From: Laura Gibbons
Sent: 08 May 2018 09:54
To: Planning.Responses
Subject: RE: Please find attached amendment on planning application Ref: FG/206/17/PL

Engineers comments relating to surface water drainage

APPLICATION FG/206/17/PL

Description of Works: Installation of a Six Pump (12 Filling Position) Petrol Filling station, Drive-to- Pay Kiosk & associated works including Jet Wash, Air/ Water Services & Vacuum Equipment

05.16049-ACE-00-XX-DR-D-50-0101-P04

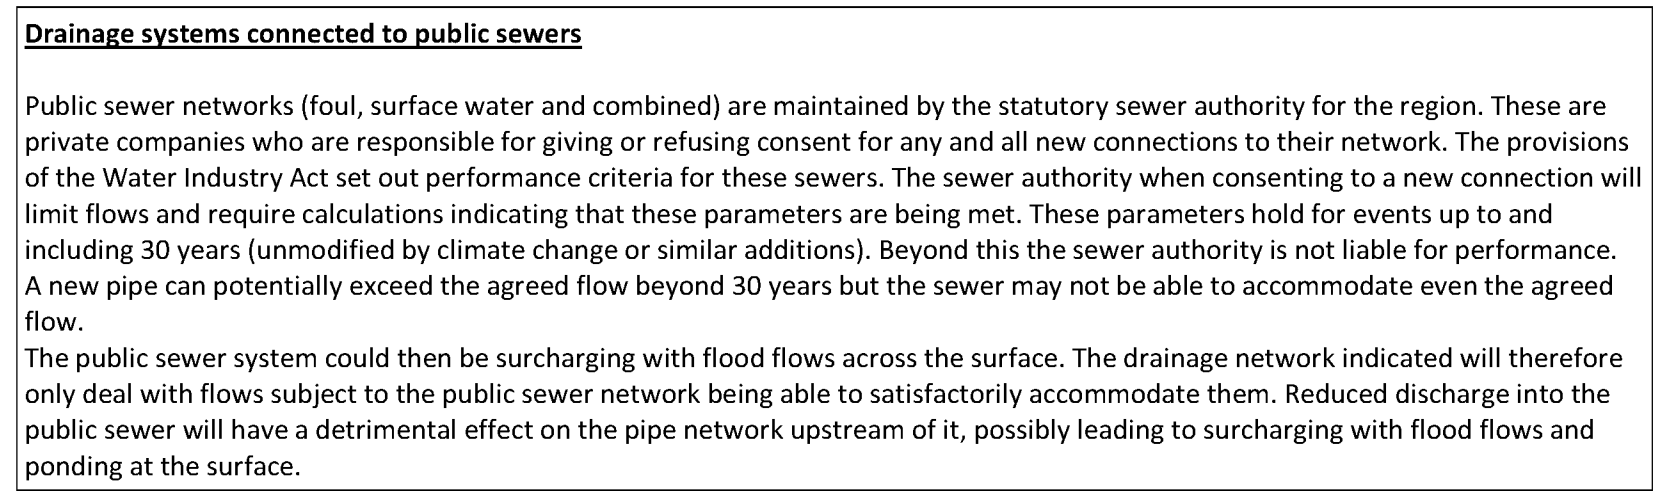
The application proposes to attenuate surface water before discharging using an existing hydrobrake to control the volume discharged from the site. It is stated that infiltration is not suitable because of ground conditions, but no evidence of winter infiltration testing has been provided. This will need to be provided.

Calculations will need to be updated to include for +40% climate change.

I am pleased to see that the drainage from the hazardous zone is to go to foul sewer and not to surface water disposal. I agree with the plans in principle, if it can be proven that infiltration is not feasible. Further details will be required to discharge the condition.
